Recommendation Report for Planning Permission for Works or Extension to a Dwelling

REF NO: R/78/19/HH

LOCATION: 17 Mill Lane
Rustington
BN16 3ED

PROPOSAL: Pitch roof side extension to replace existing garage and store.

Title
Elevations as Proposed

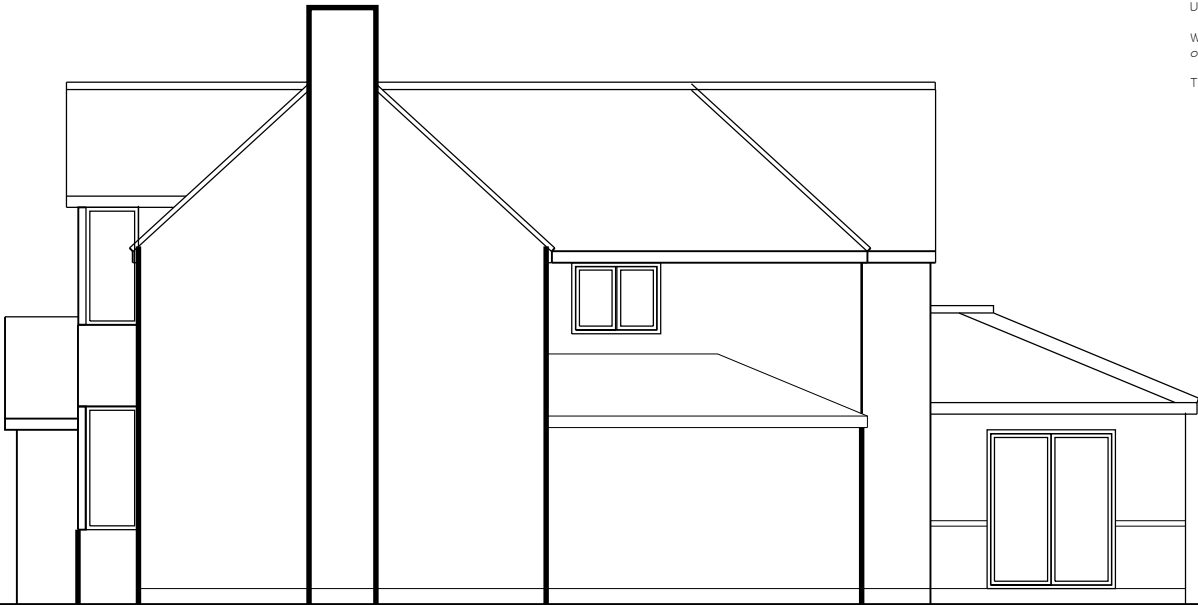
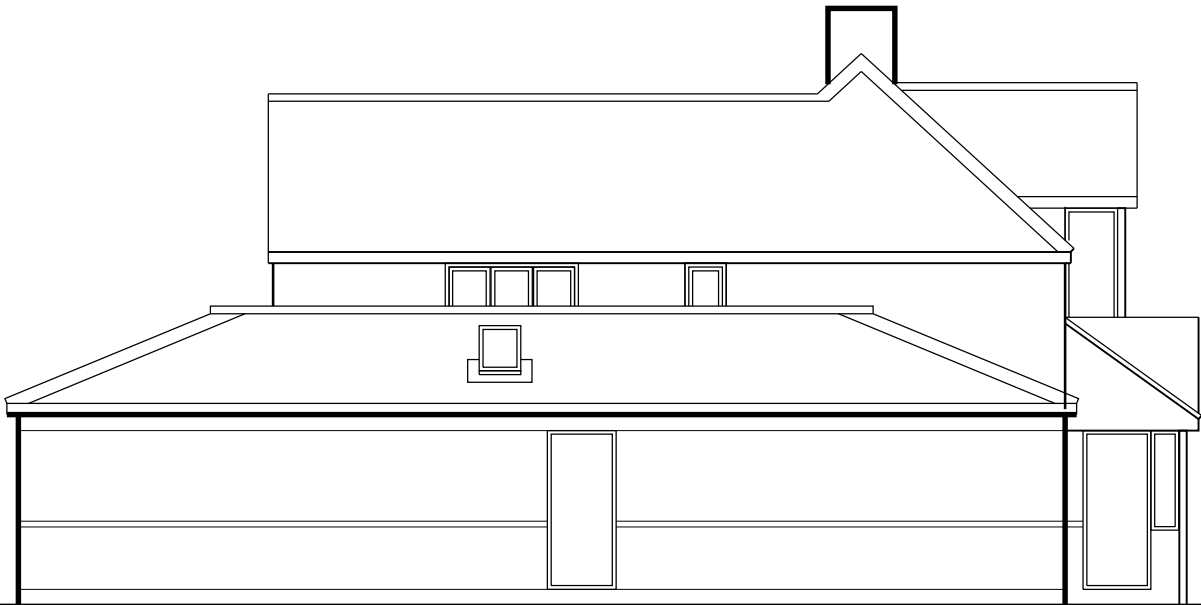
The proposed development will be visible from the street scene. However, as a result of its design and massing, it is not considered to have any significantly harmful impact upon the character of the area, or the host dwelling. The area is host to a mixture of dwelling styles, and types, with an inconsistent spatial pattern. The proposed development has a maximum height of 3.9, which is 3.5m lower than that of the ridge height of the host dwelling. This is considered to allow the proposed extension to appear subservient to, and well integrated with, the host dwelling. Therefore, it is considered that the proposed development is in accordance with D DM1, D DM4(a) and (b) of the Arun Local Plan.

The proposed development is not considered to have any significantly harmful impact upon the residential amenities of neighbouring dwellings, by way of overshadowing or overbearing impact. Whilst it is noted that the proposed extension has a maximum height of as a result of the slope angle of 22 degrees, the roof slopes to an eaves height of 2.6m, when 1m from the boundary with the adjacent property to the South. It is considered that as a result of the scale, siting and aspect of the development, the proposed development is considered to be in accordance with D DM1(3) and D DM4(c) of the Arun Local Plan.
